T-MOBILE SITE NUMBER: DN06164A
T-MOBILE SITE NAME: SPRINT RETAIN SITE DN14XC248
T-MOBILE PROJECT: SPRINT RETAIN

BUSINESS UNIT #: 877034
SITE ADDRESS: LUCKY FOUR RANCH, WEST HWY 24
GREEN MOUNTAIN FALLS, CO 80819
COUNTY: EL PASO
SITE TYPE: MONOPOLE
TOWER HEIGHT: 60'-2"

C-1.1

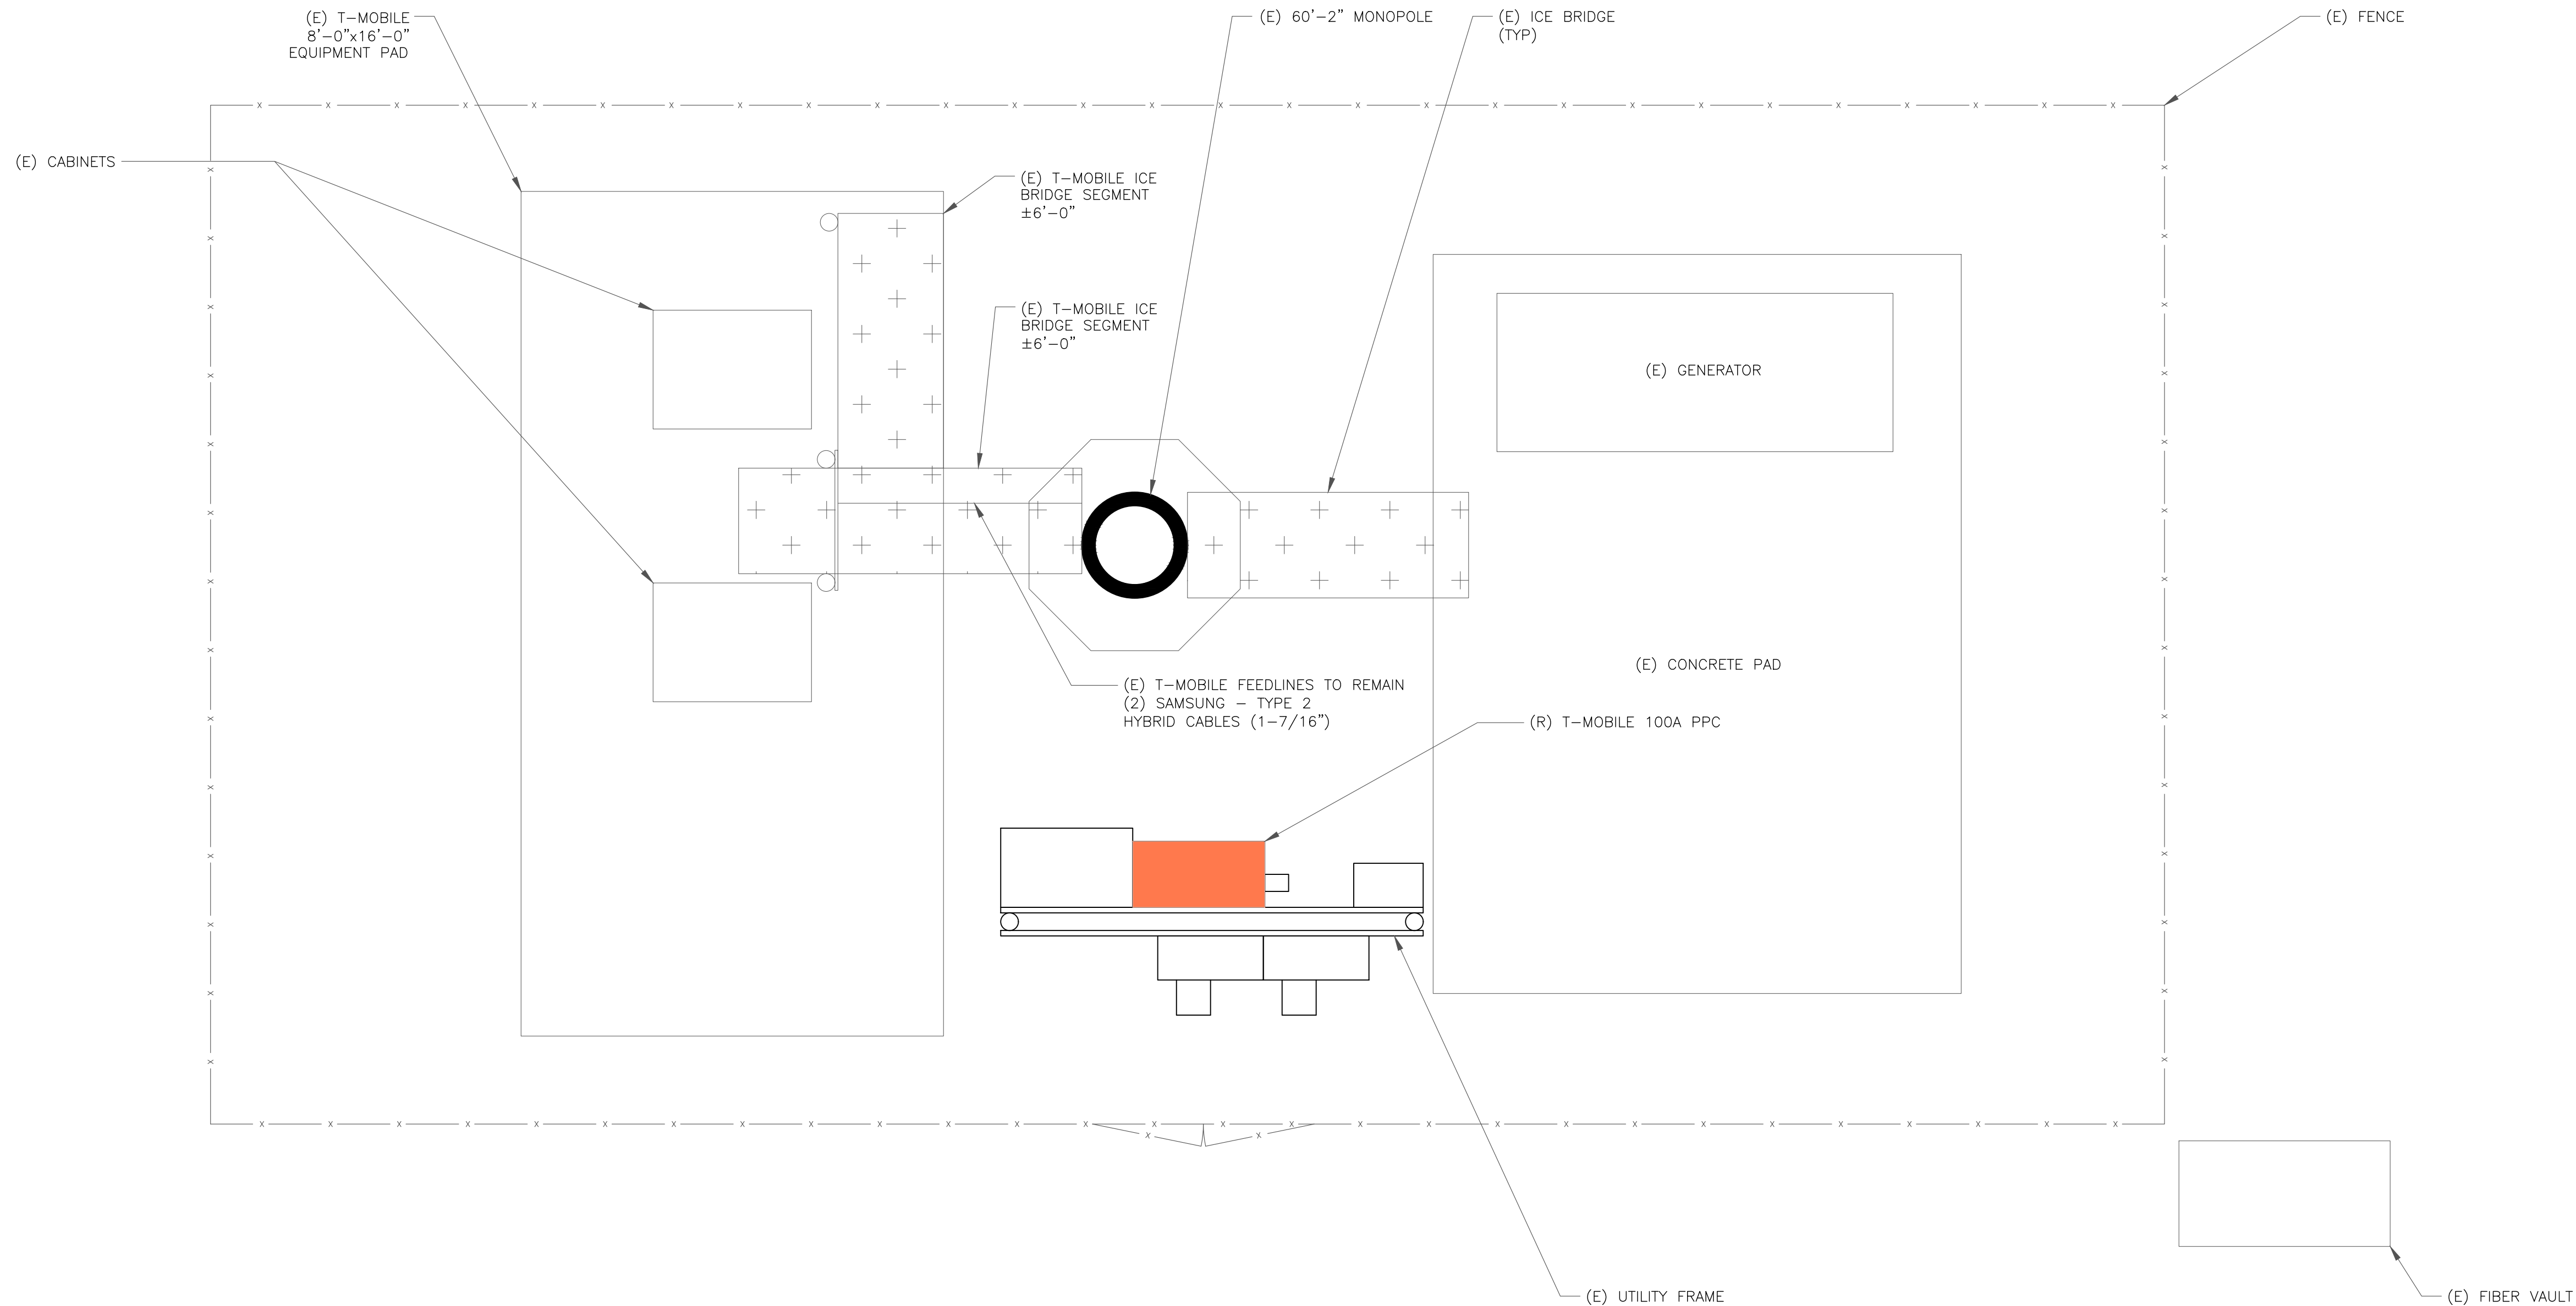
Please add "PCD File No. PPR-21-070" to the site development plan.

Please add the following:
- Owner name, contact telephone number, and email for responsible party
- Applicant name (if not owner), contact telephone number, and email for responsible party
- Plan preparer name, telephone number, and email
- Property address
- Legal description
- Lot/parcel size
- Lot area coverage calculation
- Total gross building square footage
